Application number: 2023/91483	
What is the application for?:	Demolition of garage and erection of detached dwelling
Address of the site or building:	adj, 33a, Church Lane, Clayton West, Huddersfield, HD8 9LY
Postcode:

Description
PROPOSED PLANS & ELEVATIONS

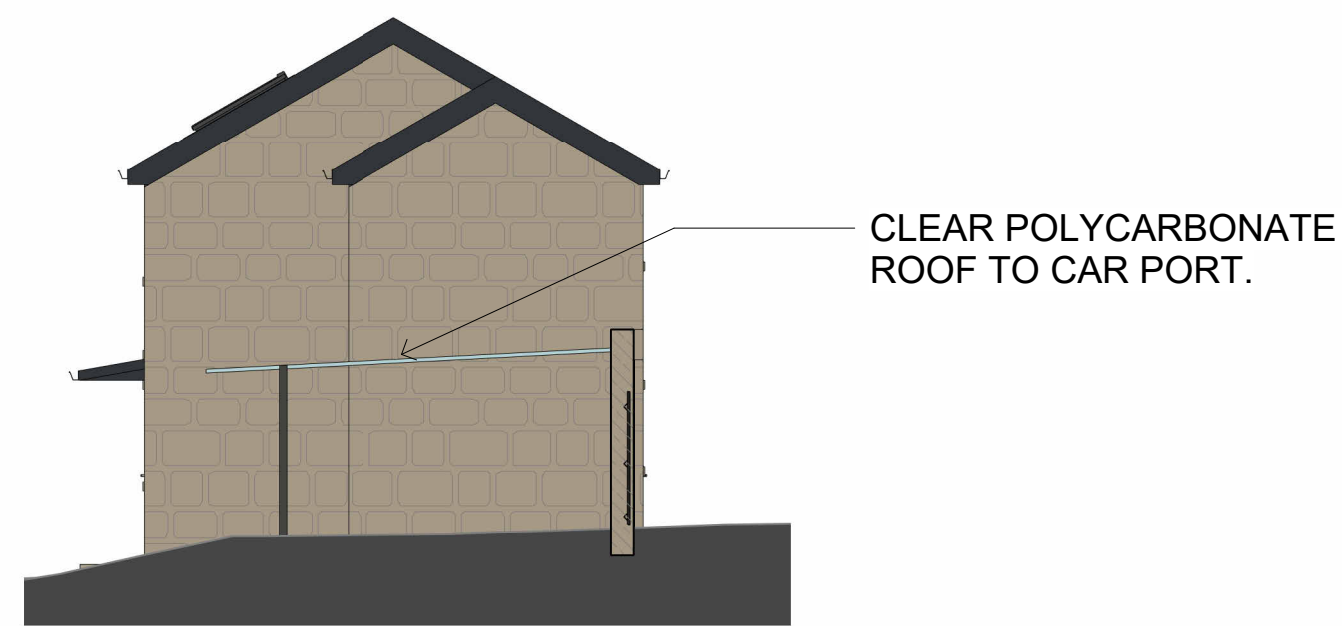
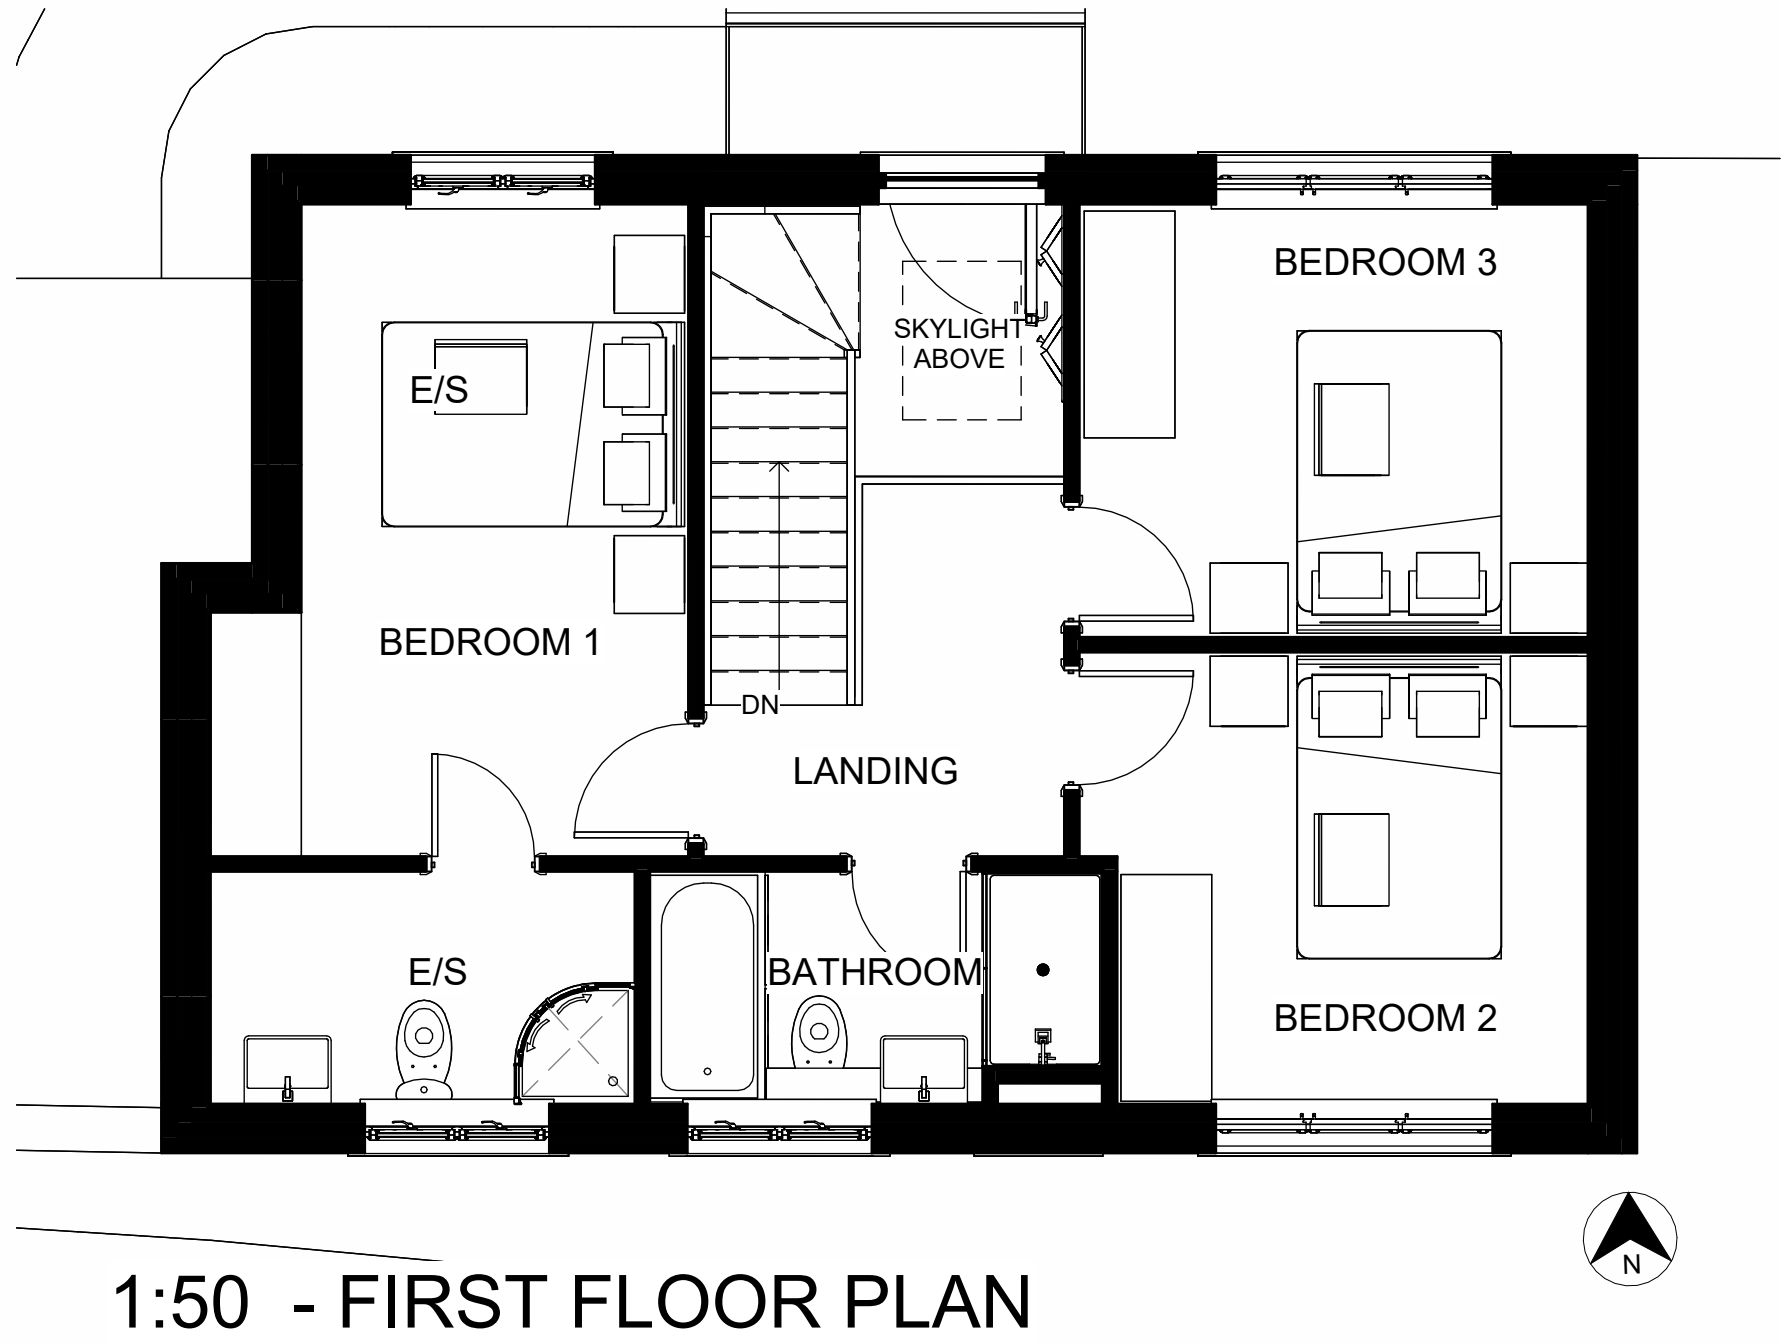
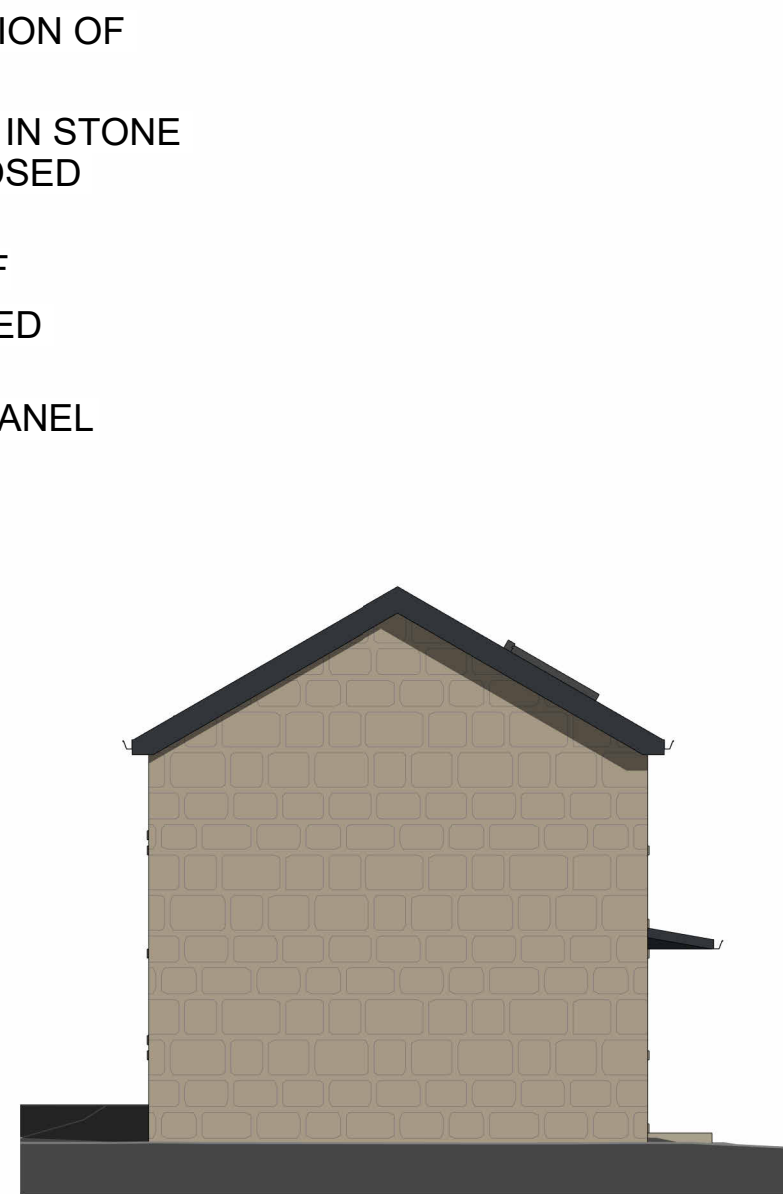
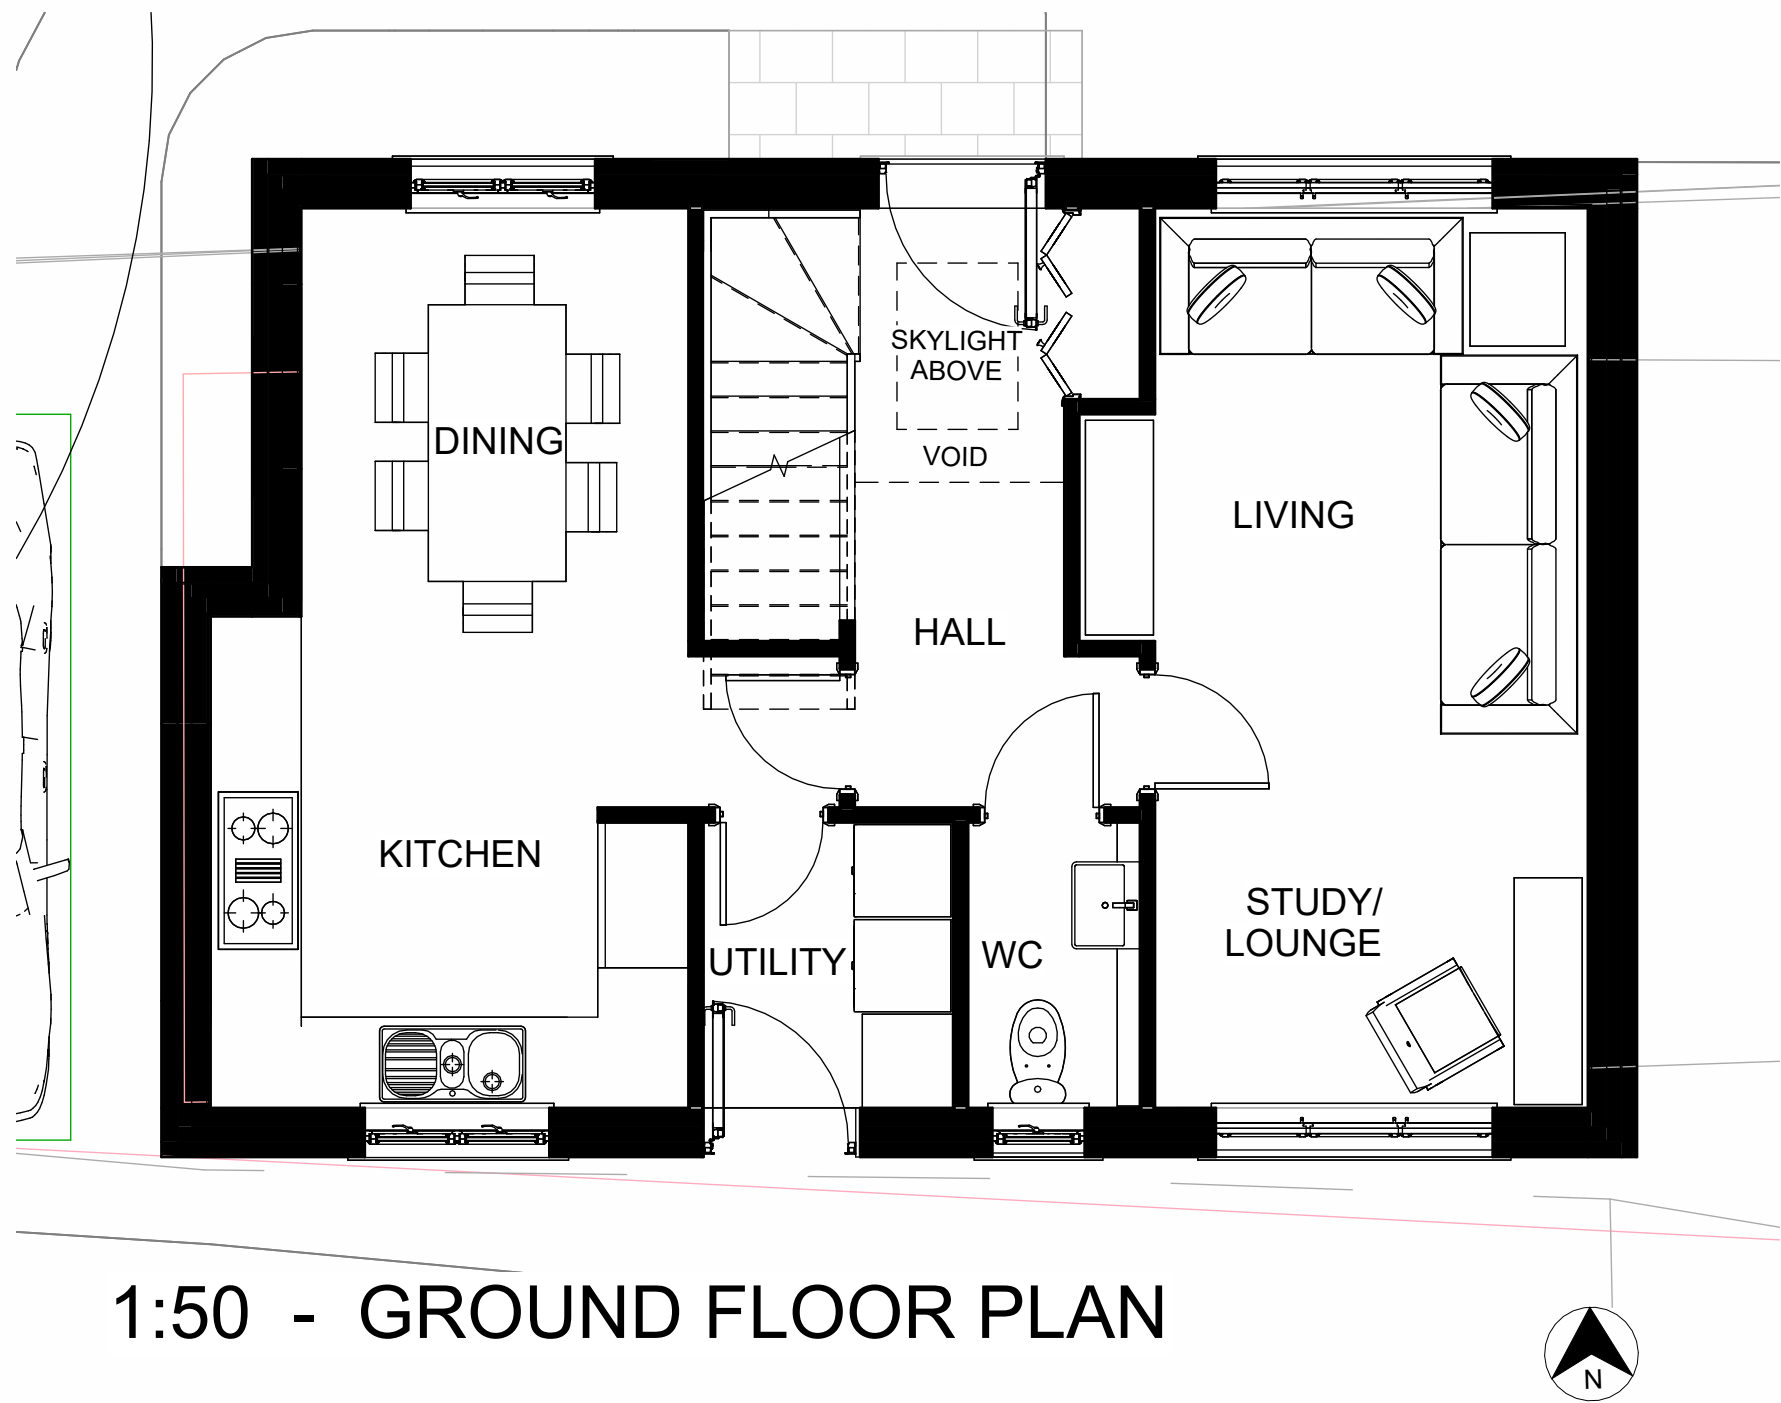
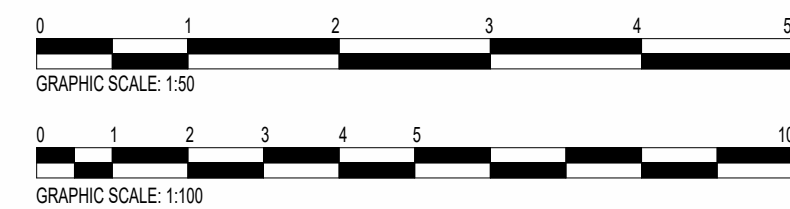
finally aside from the impact on the character of the area the design itself is far removed from the aesthetic of the area. It is another generic new build with a poor-quality appearance that is detrimental to the appearance and history of existing local houses and buildings. In addition to this, it could have a negative impact on neighbouring house prices
